From: Martyn White <Martyn.White@arun.gov.uk> **On Behalf Of** Conservation Officer
Sent: 16 June 2026 17:19
To: Planning.Responses <Planning.Responses@arun.gov.uk>
Cc: Harry Chalk <Harry.Chalk@arun.gov.uk>
Subject: LU/102/26/L

LU/102/26/L

Address: Court Wick Park Courtwick Lane Littlehampton BN17 7PD

Proposal: Listed building consent for internal and external alterations to building to facilitate conversion and change of use to a children's care home, reinforcement of brick and flint garden wall with buttresses and reconsolidate wall with coping courses.

Drawing Buttress detail

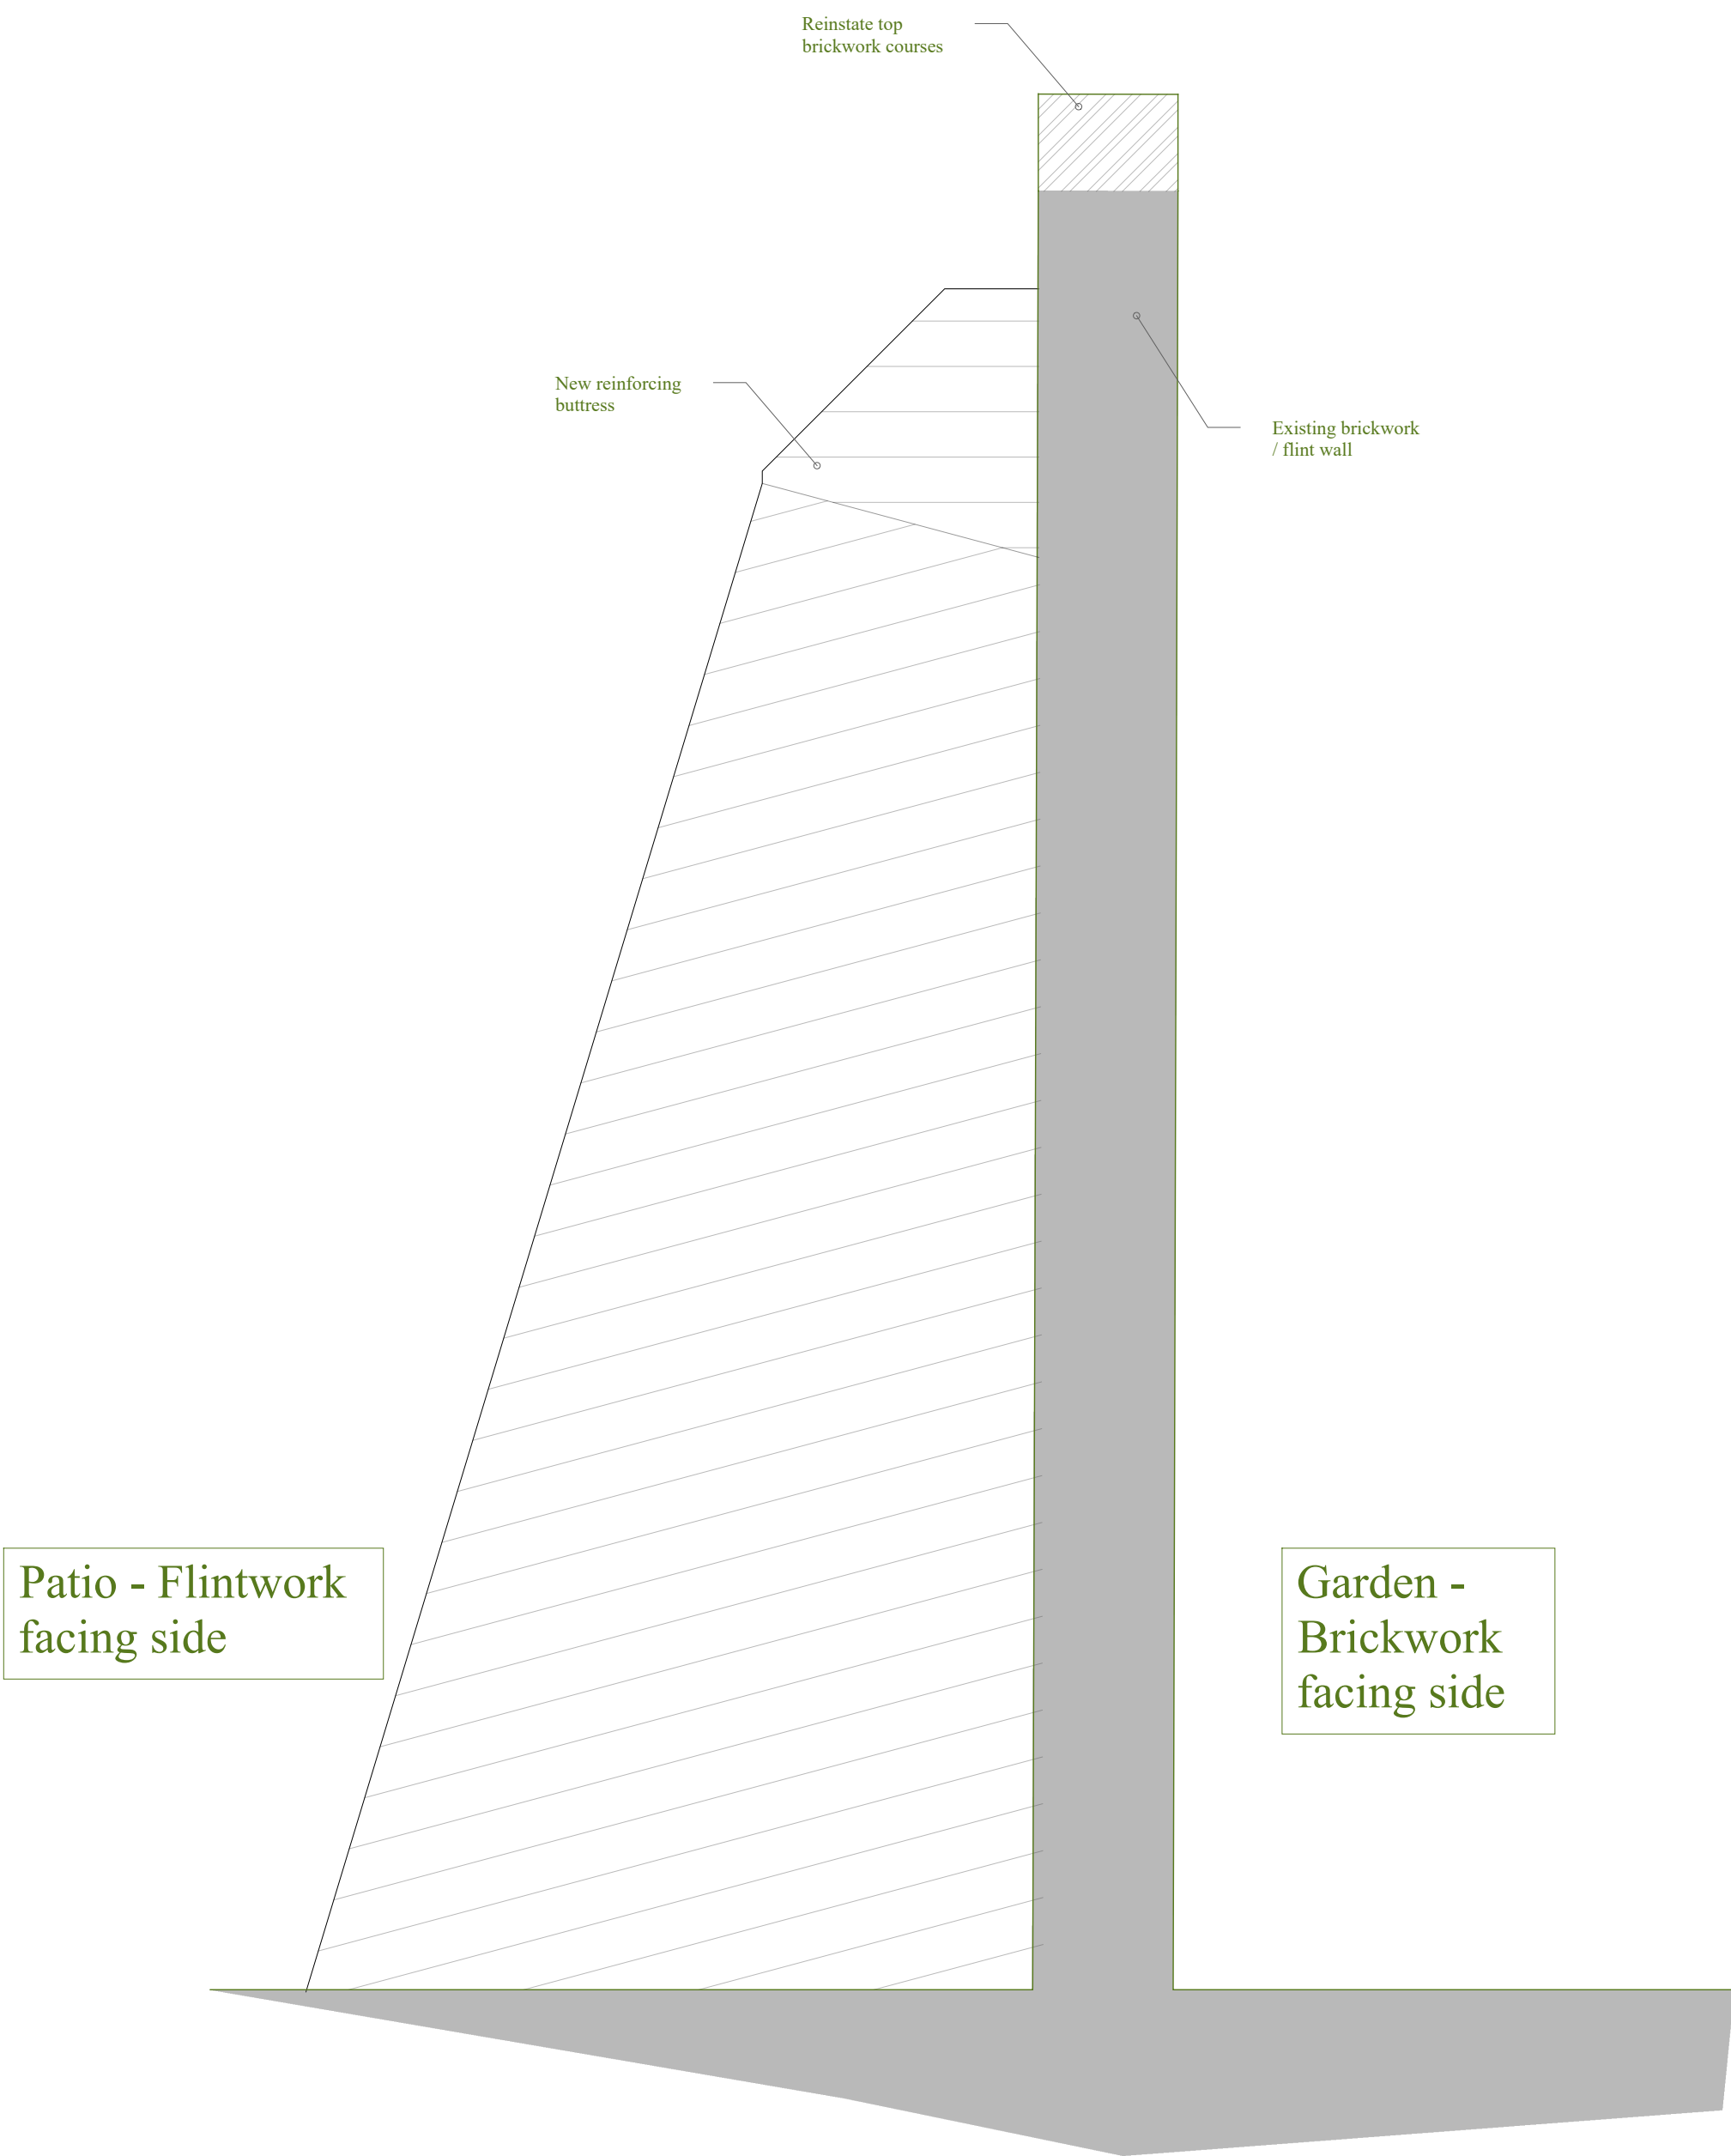
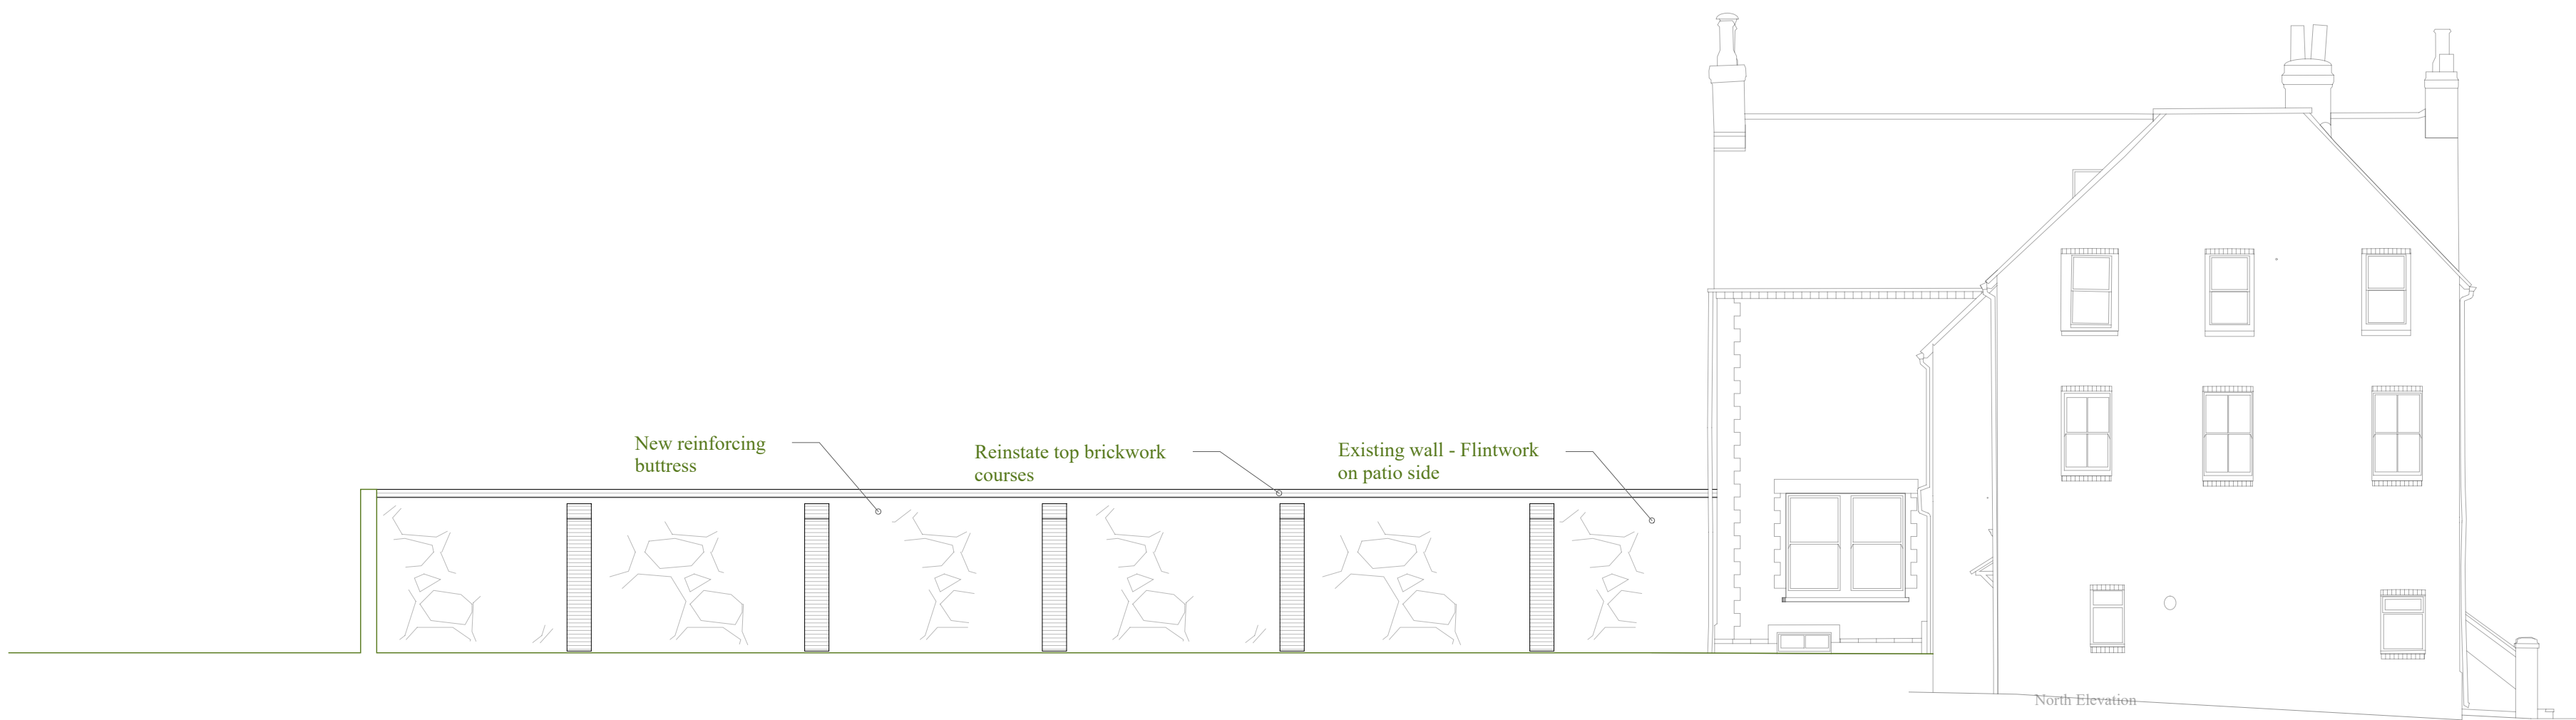
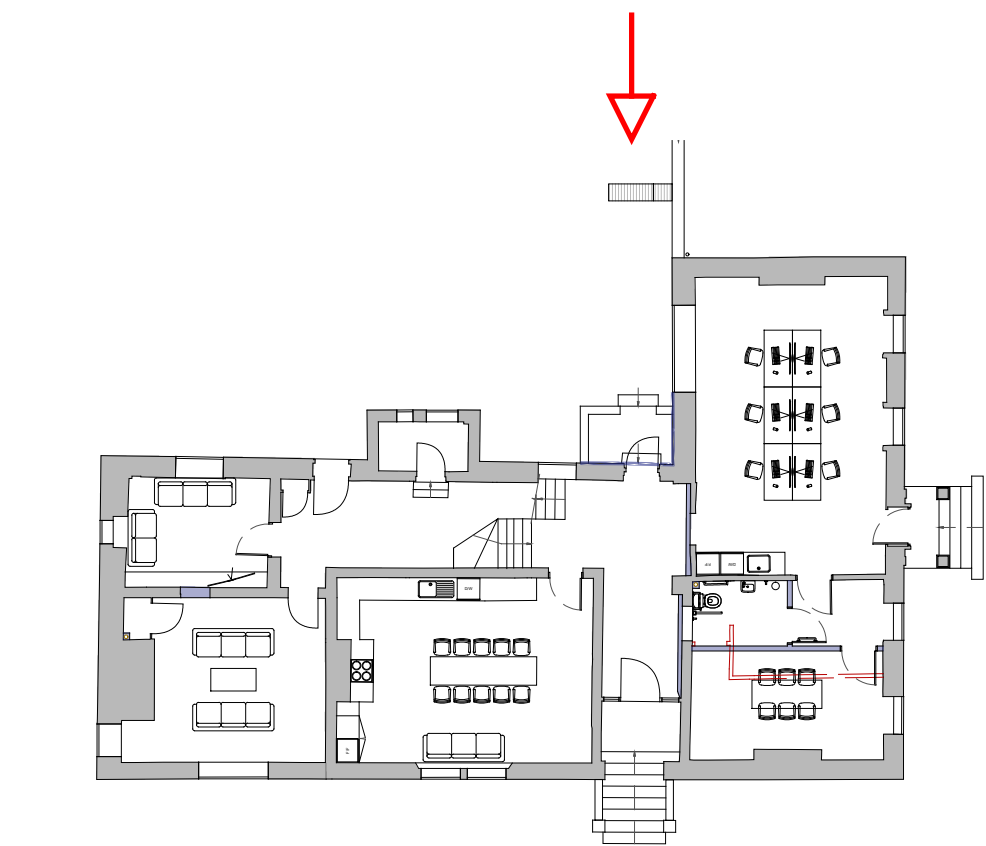
The existing flint and brick wall to the west of the building is clearly of significance and makes a positive contribution to the character of the site. Its retention is therefore essential. It is acknowledged that a number of repair and protection options have been considered, and the proposed approach appears to represent the least harmful intervention to the historic fabric and is therefore acceptable.
